Date: 14th November 2022

**Sherringham Shoal & Dudgeon Offshore Wind Farm Extension Projects
APPLICATION REFERENCE No. EN010109**

**Application by Equinor New Energy Ltd for an Order Granting Development Consent
for the Sherringham & Dudgeon Offshore Wind Farm Extension Projects – Relevant
Representation by The East of England Ambulance Service NHS Trust (EEAST)
Pursuant to Section 56 of The Planning Act 2008**

EEAST has reviewed the DCO application documentation and raises a non-statutory **HOLDING OBJECTION** on the following basis:

See Map 1 (sheet 3)

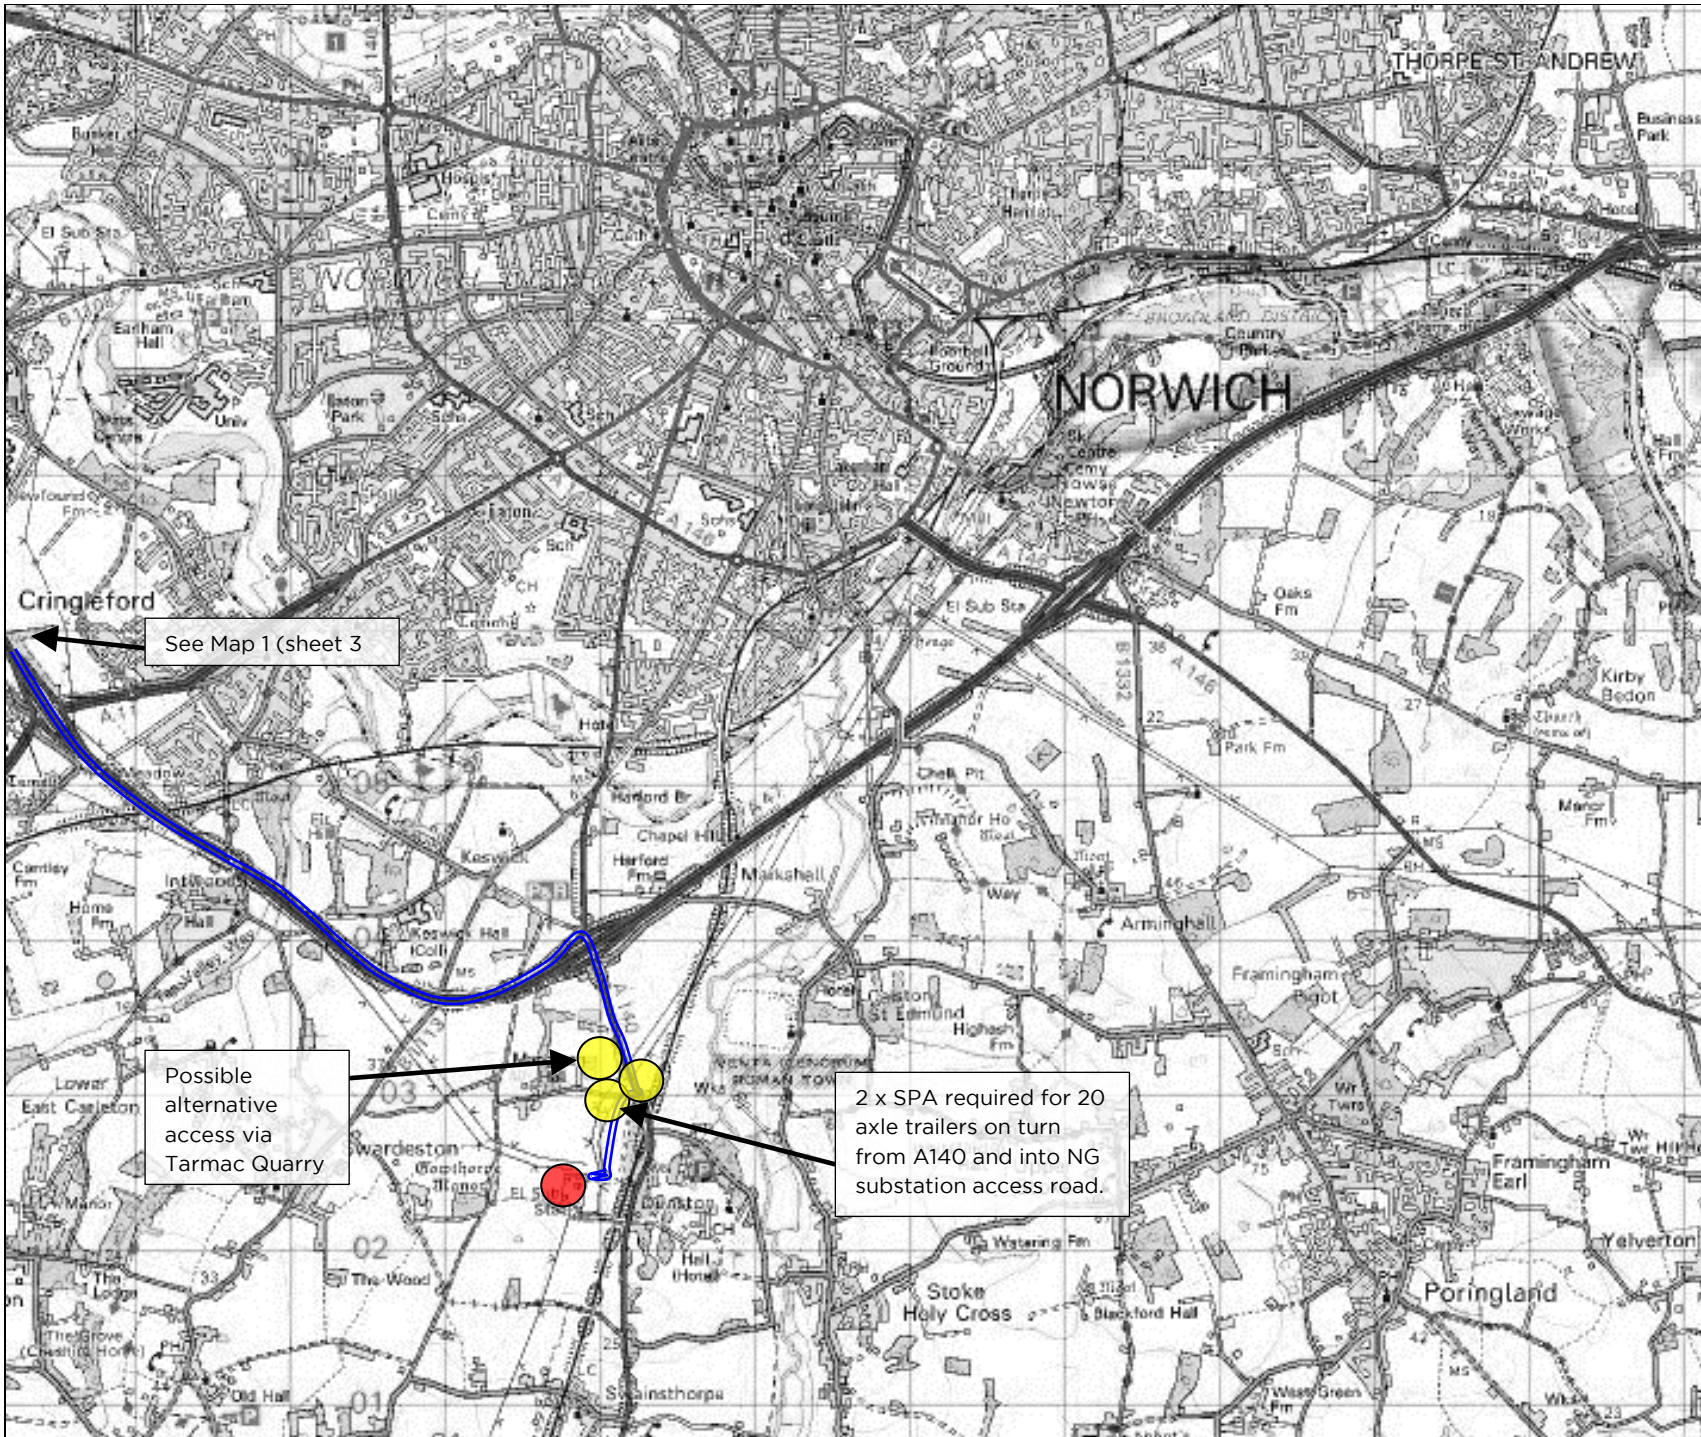
Whilst the scope of the Report is principally focused on 'route planning feasibility' from Kings Lynn Port to Norwich, which remains unresolved at present due to highway structure and land constraints, it is evident that ALL's are likely to be a key highway network impact requiring appropriate mitigation and management.

It is noted that the Transport Chapter of the ES does not seem to address the issue of ALL's, and information is therefore required on the forecasted number, type, route selection, timing and duration of these highway related impacts.
